Planning Application Ref: BR/105/17/T

Location: Servite House, Servite Close, Bognor

Description of works: Fell three Sycamores

PROPOSED TREE WORKS AT SERVITE CLOSE,
BIGNOR, WEST SUSSEX.

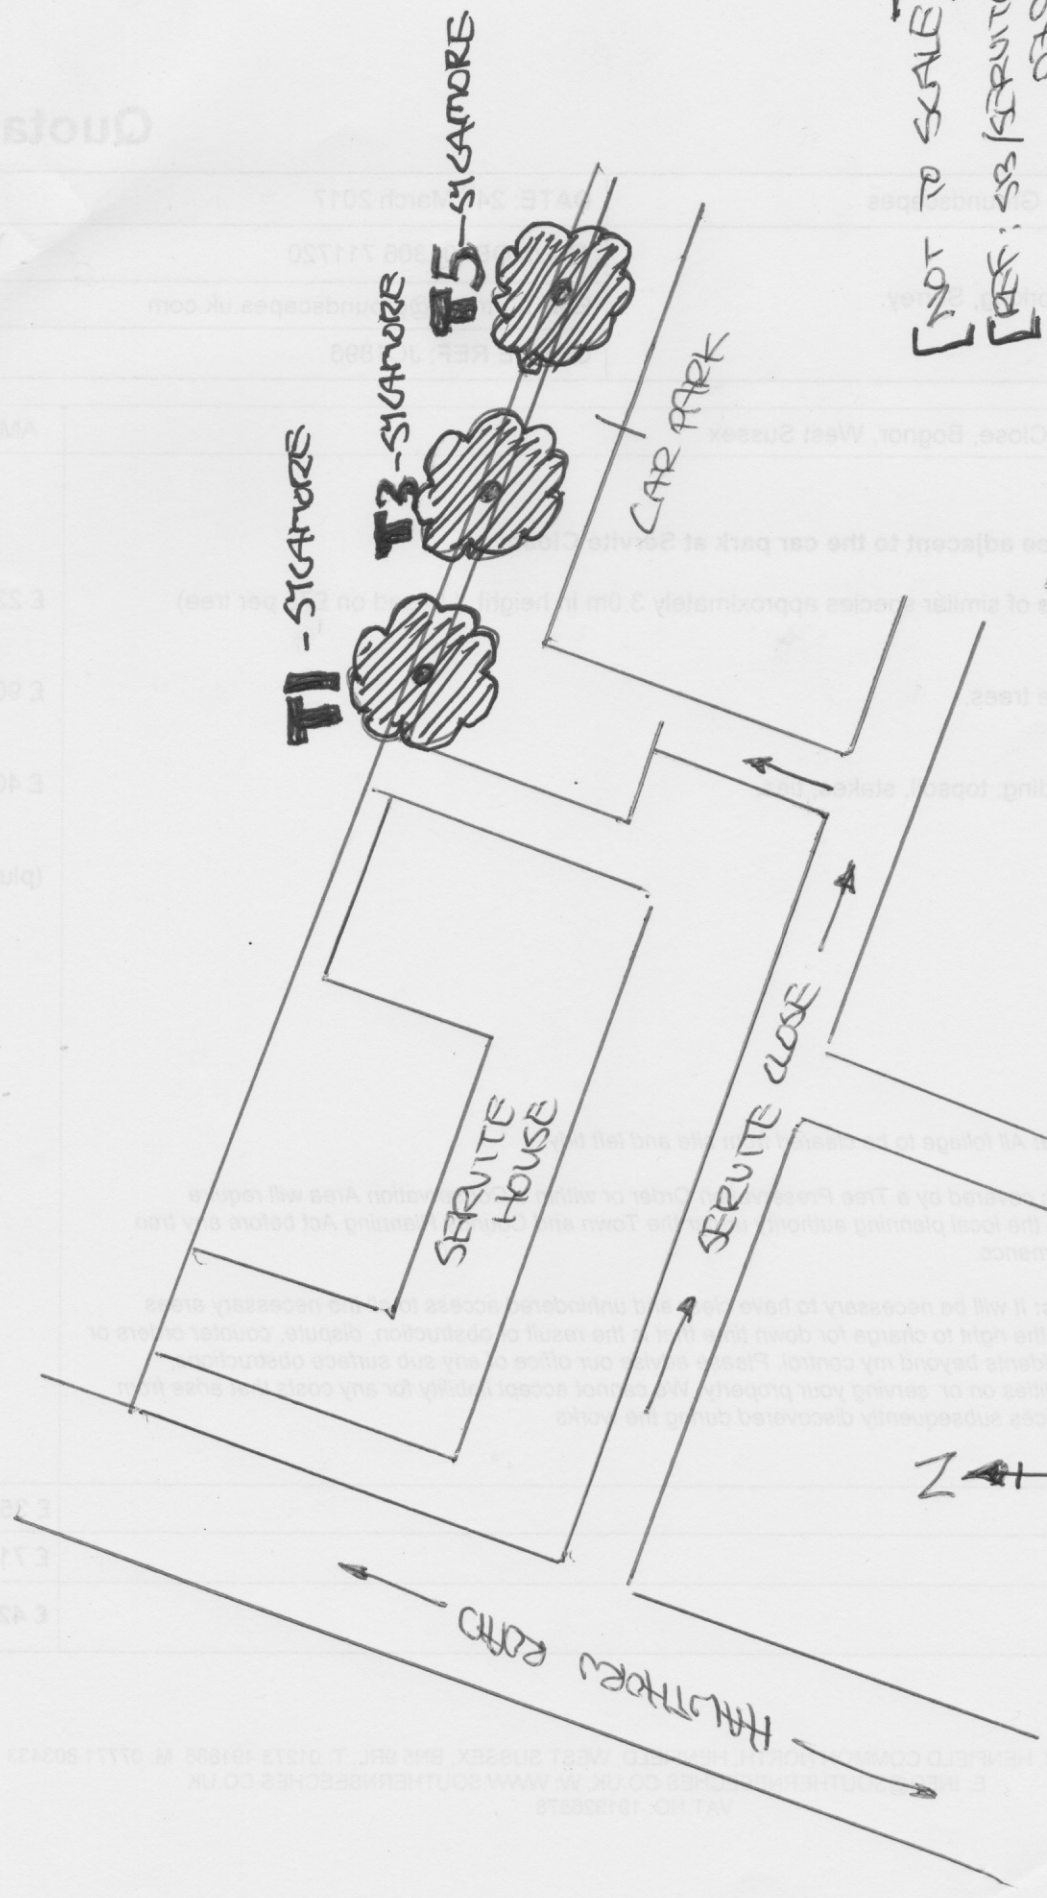
- They are the only trees in what is otherwise a barren parking area behind the buildings on Servite Close and they are sound and healthy and contribute to the amenity of the car parking court being clearly visible from Servite Close.
- These trees have self-seeded into a narrow band of soil held back by a low retaining wall at the car park edge with a high boundary wall at their backs. Under these circumstances root pressure will always win over a low retaining wall and from time to time repairs will be necessary – but there is no safety issue here.
- Aphid drip is a problem with the paintwork on cars but these trees are all at one end of what is an extensive parking area and on the occasion of my visit there was only one small car present and that had been parked underneath the trees.

- These trees have heightened importance being the only trees in the car park and I would see their complete removal on aphid drip grounds as an excessive and unacceptable remedy to the problem.

- I recommend **REFUSAL** of the application - as the works are excessive and unacceptable resulting in a total loss of amenity.

- Recommend that the applicant re-submits seeking a crown lifting exercise to give the trees a more upswept form on the south side above the car park.
- Another option might be to remove the middle tree and plant a replacement tree for the future whilst crown-lifting the other two trees. Manage the situation by future pruning operations until the new tree is fully established and then go in for the removal of one more tree with a replacement and then in time come back in for the last Sycamore to be removed and replaced thus phasing the work over time with continuity of landscape and no loss of amenity.
